**FFERM WYNT ALLTRAETH AWEL Y MÔR ARFAETHEDIG / PROPOSED AWEL Y MÔR OFFSHORE WINDFARM**

**CYFEIRNOD YR AROLYGIAETH GYNLLUNIO / PLANNING INSPECTORATE REFERENCE: EN010112**

**RE: NATURAL RESOURCES WALES' WRITTEN SUBMISSION FOR DEADLINE 3a**

This image provides landscape and visual context only

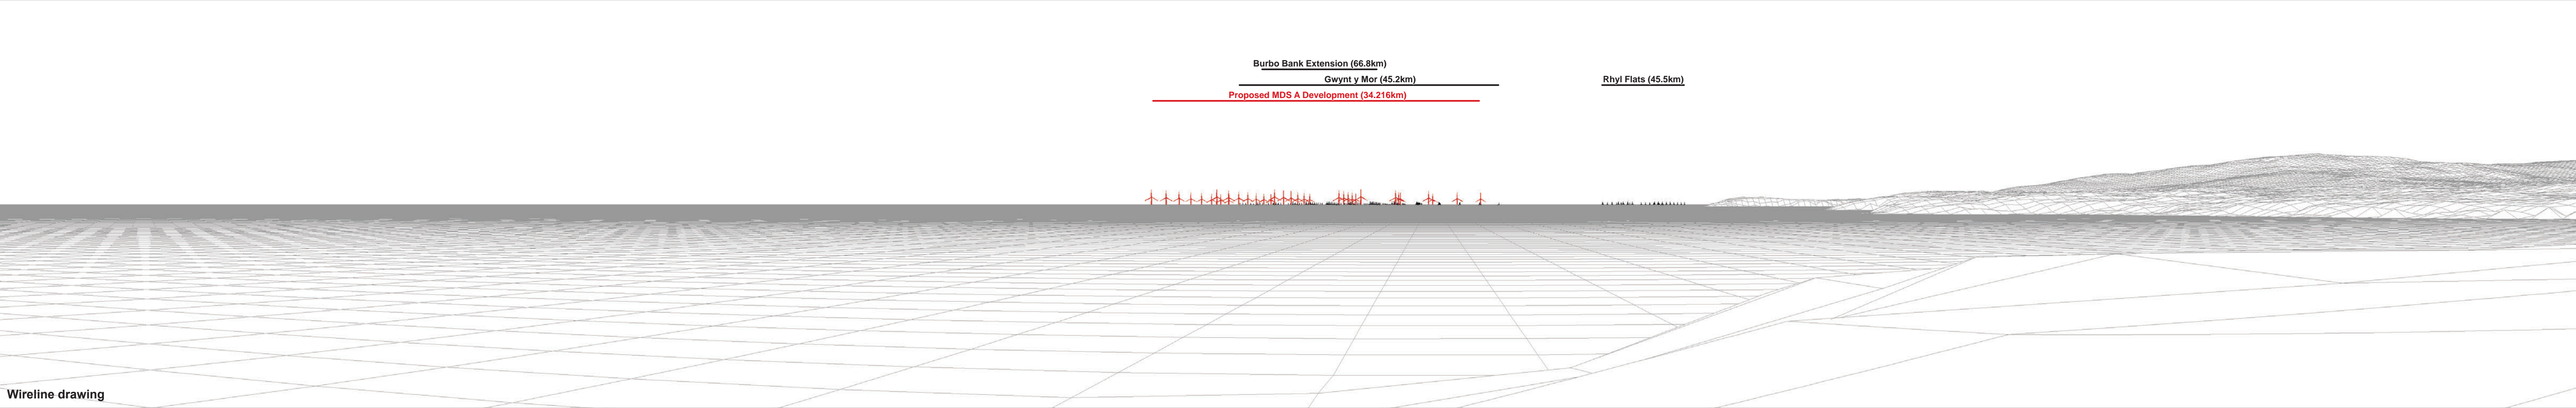
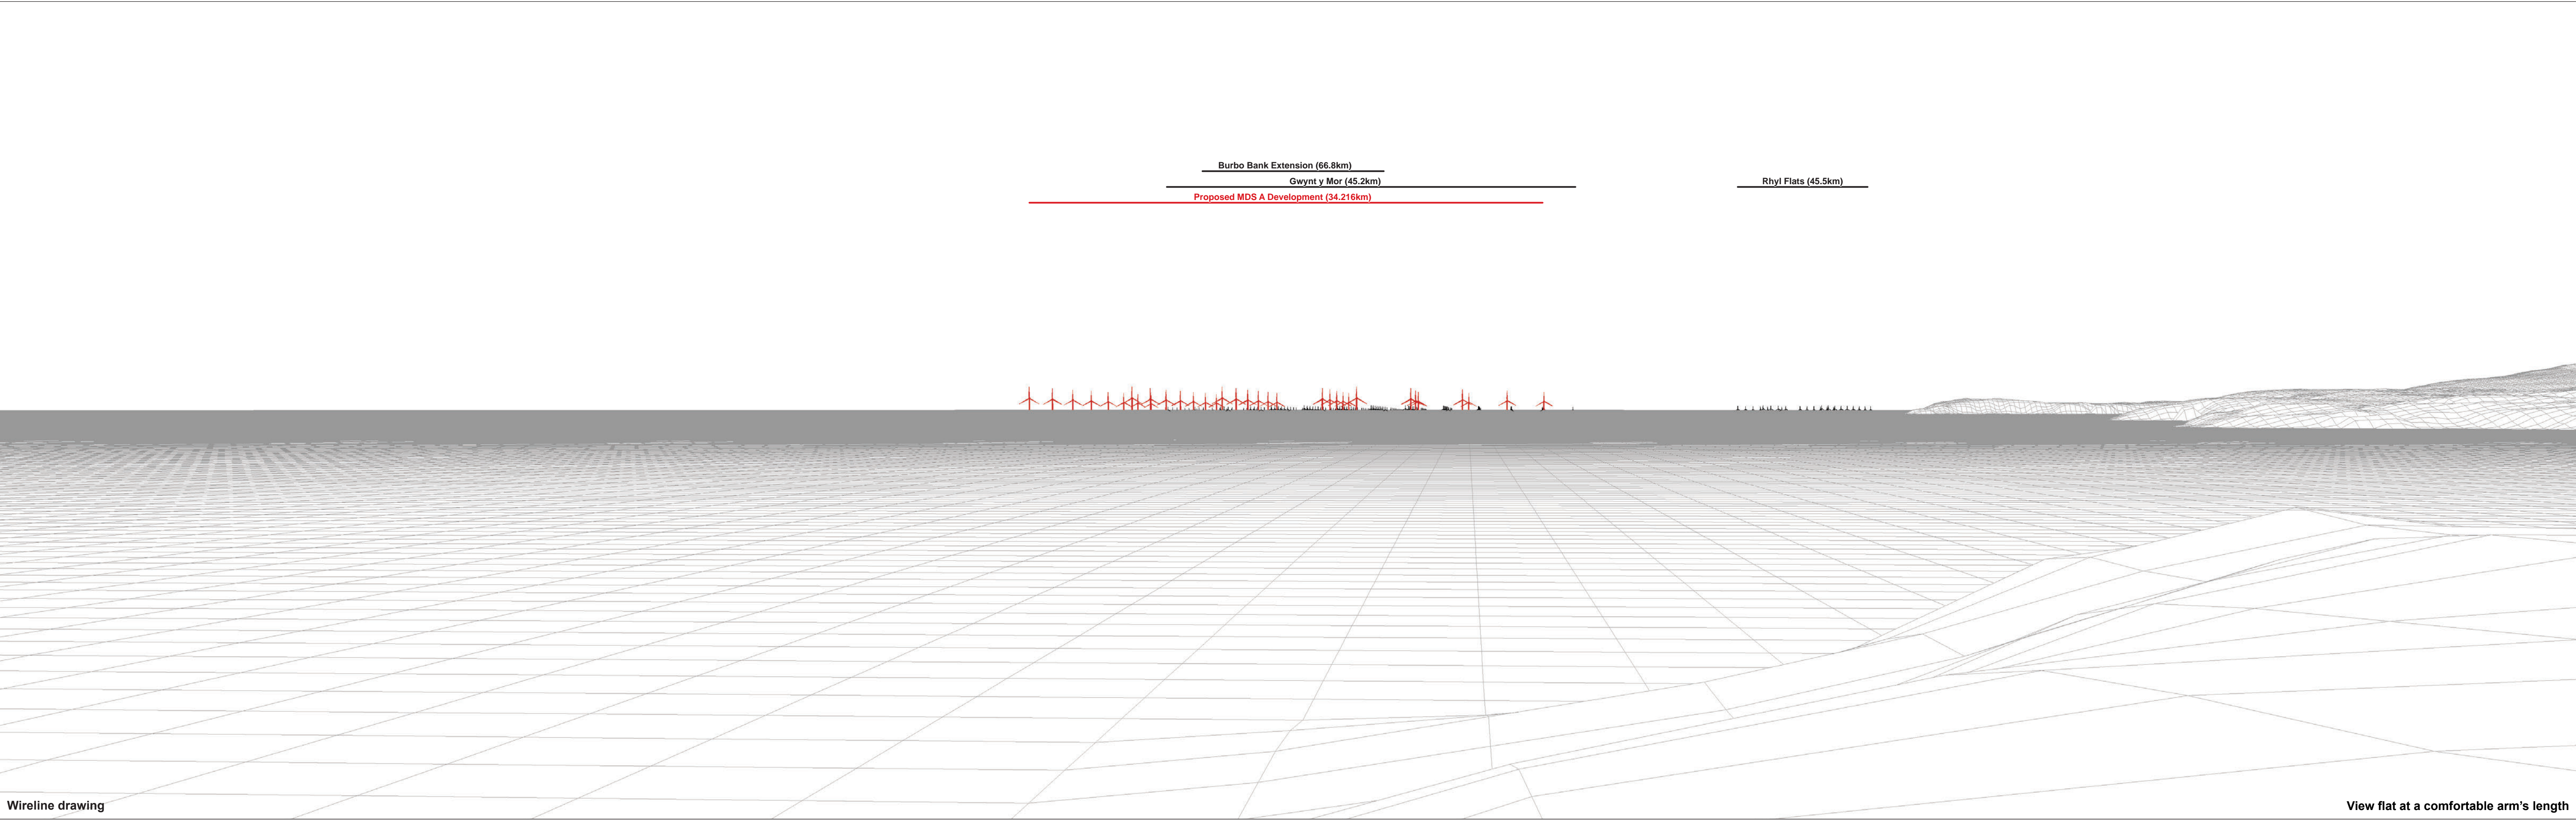
- 2.5. In relation to viewpoints (VP) 1 (Porth Llechog/Bull Bay) [APP-230], VP2 (Trwyn y Balog/ Point Lynas) [APP-231] and VP3 (Mynydd Eilian) [APP-232], we consider that the effects at these viewpoints have been underestimated in the SLVIA. We consider the effects to be of low-medium magnitude, and that this level of magnitude combined with high sensitivity should lead to an assessment of moderate adverse effects, which we consider significant. We consider the threshold for significance has been reached for VPs 1, 2 and 3.

- 2.6. From these viewpoints, highly sensitive receptors (e.g., walkers on the coastal path) are focused on the coastal landscape and sea views. Although there are large-scale sea views, the scale and nature of the development would make it very noticeable and focus attention upon it. Sea views and the coastline are the key focus of views in the predominantly coastal AONB and sea views are currently untrammelled by development or any other significant human activity, apart from the occasional ship. This part of the AONB is relatively remote and tranquil. The existing offshore windfarms to the east, including Gwynt y Môr, are extremely hard to discern even in fine weather and built development along the coastline is not similar in nature or scale to the proposed wind farm. The proposal would interfere with the appreciation of the open sea and coastline including views of coastal landforms and the mountains of Eryri (Snowdonia). Windfarms inland, as seen from Mynydd Eilian, are smaller scale and associated with the inland rural landscape and not sea views and the coastline.
